Planning &amp; Urban Development Department

February 8, 2016

Re: 11 Ocean St. – CBL 090 B003 – IR-2 Island Residential Zone – Shed

A Proposed Site Plan

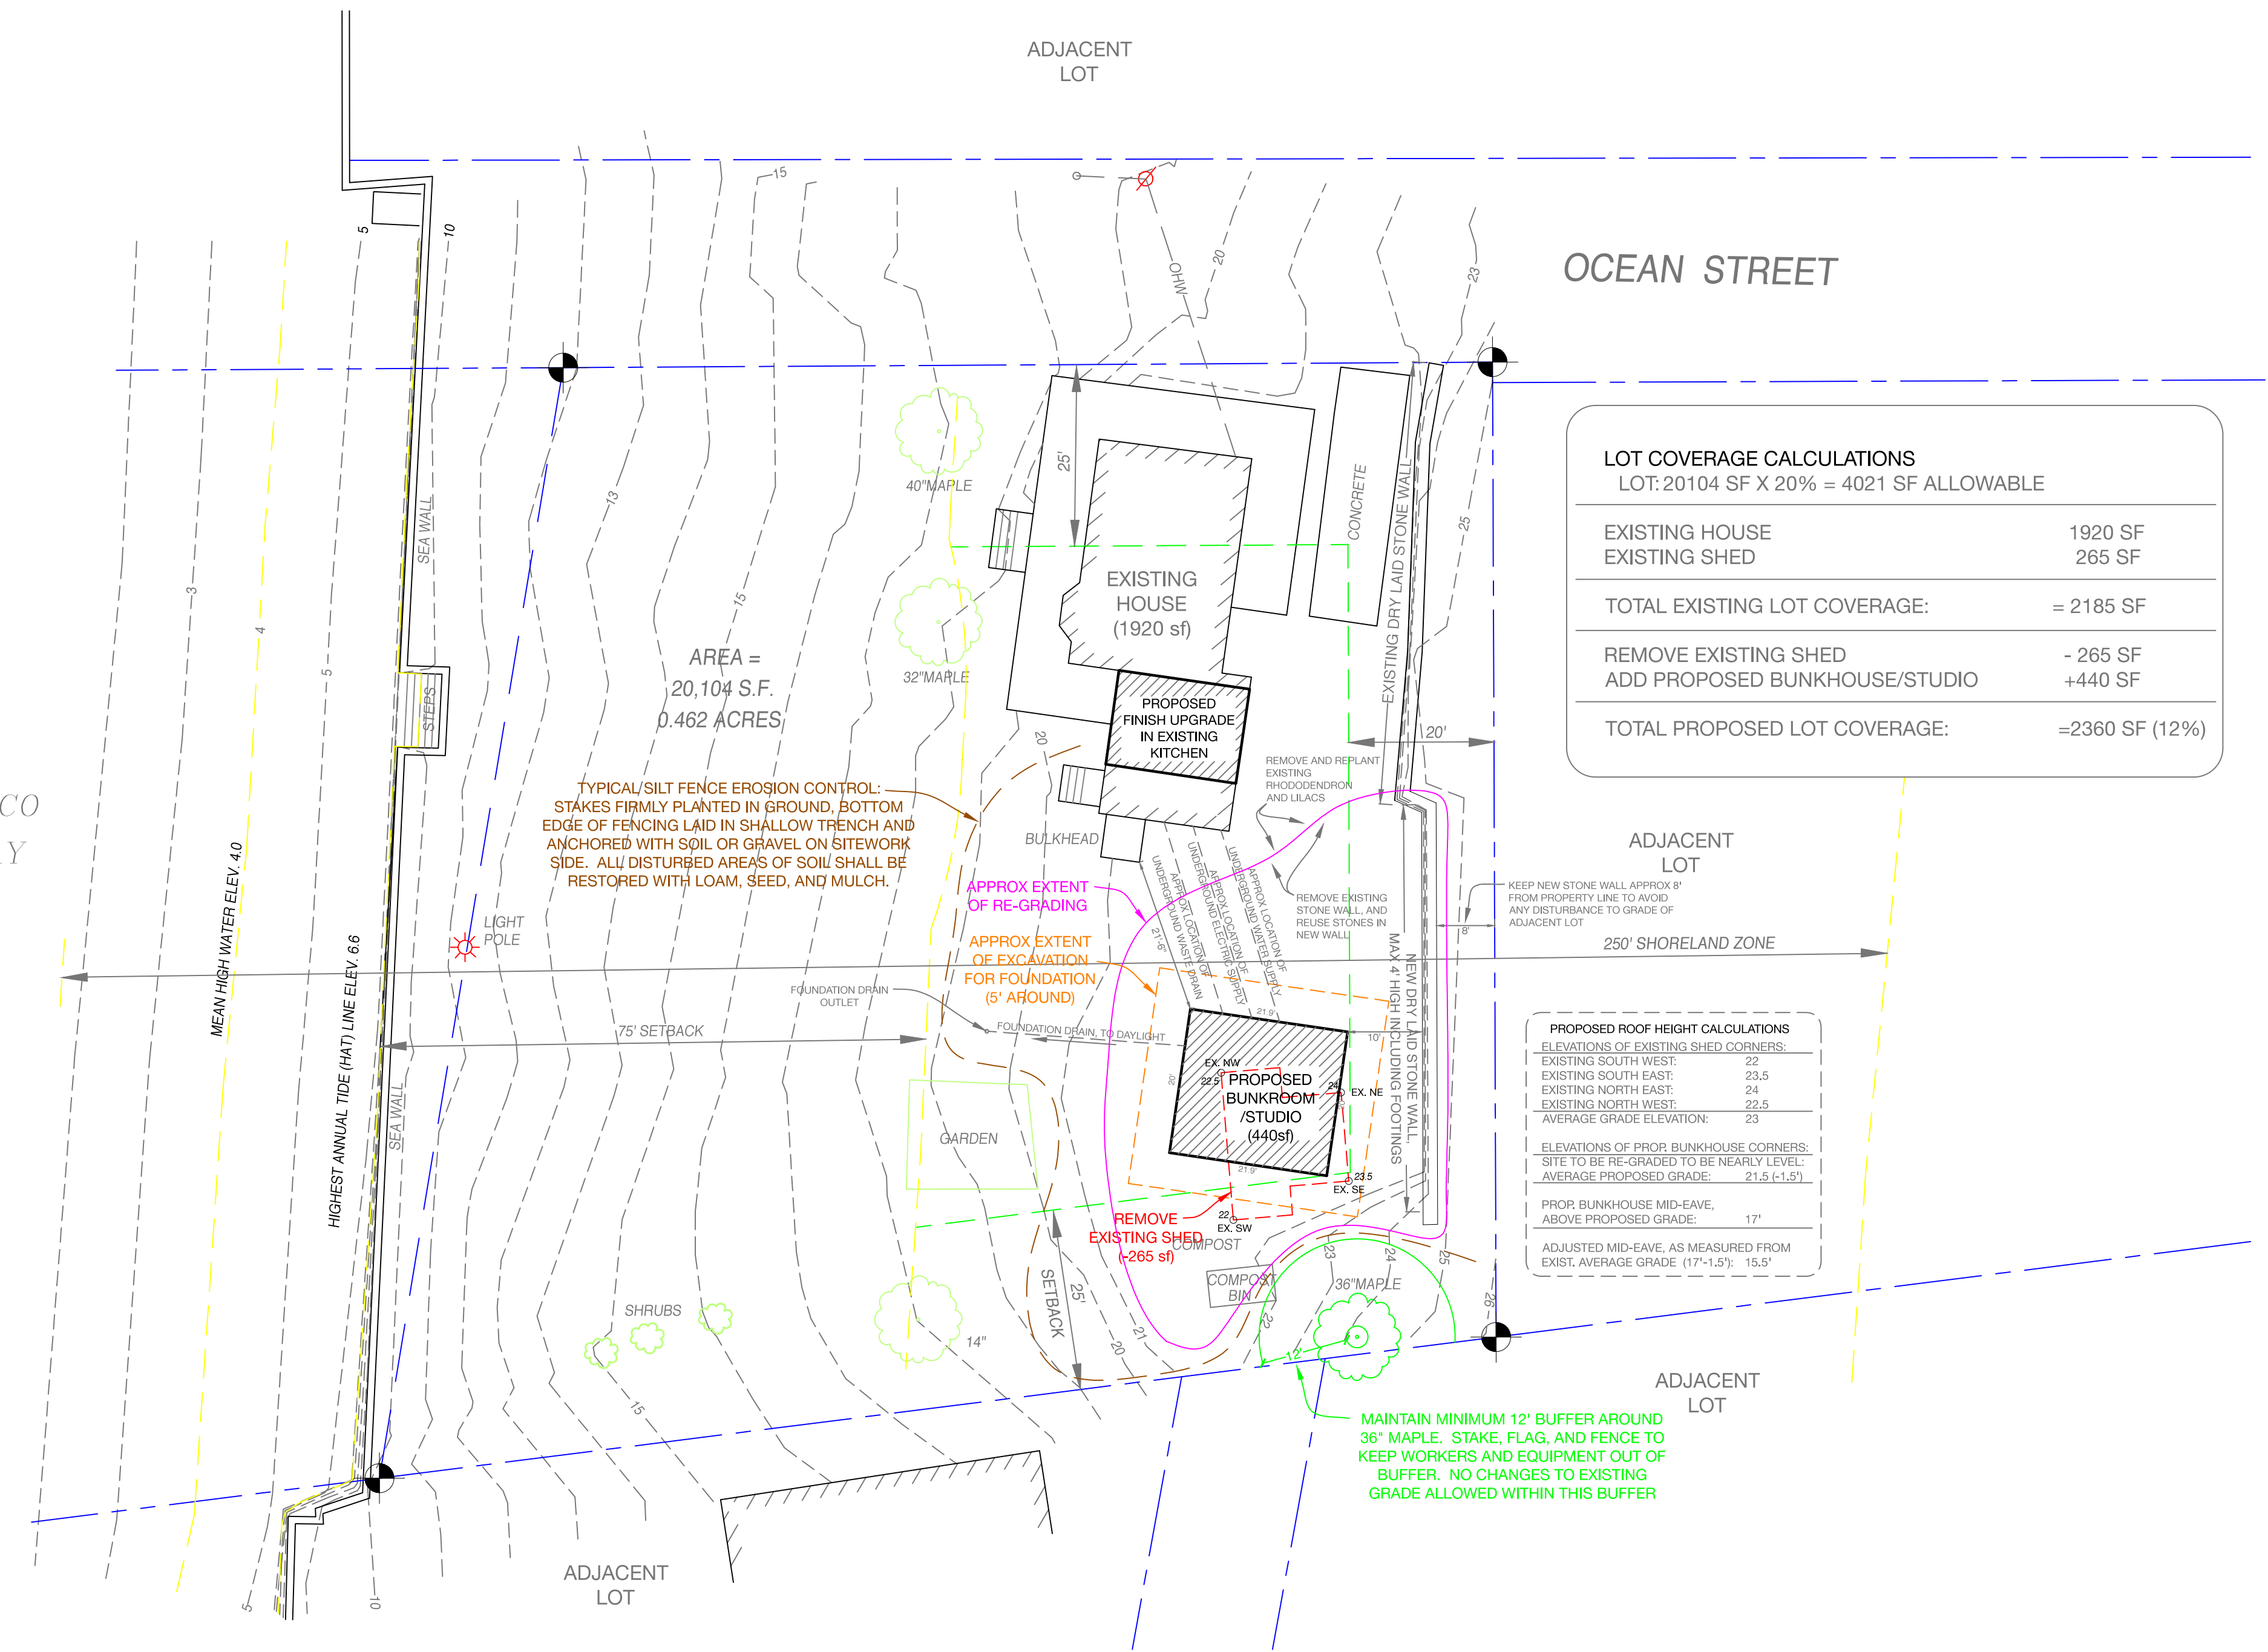
The shed as constructed cannot be permitted because it does not meet the required rear yard setback of 25 feet. You need to bring your property into compliance by relocating or removing that portion of the shed that does not conform to the required setback, and also by obtaining permit approval for any remaining portions of the shed that exceed the originally-approved dimensions.

Enclosed please find a building permit application. You have thirty days to submit a completed permit application for the removal and/or alterations necessary to bring the shed into compliance.
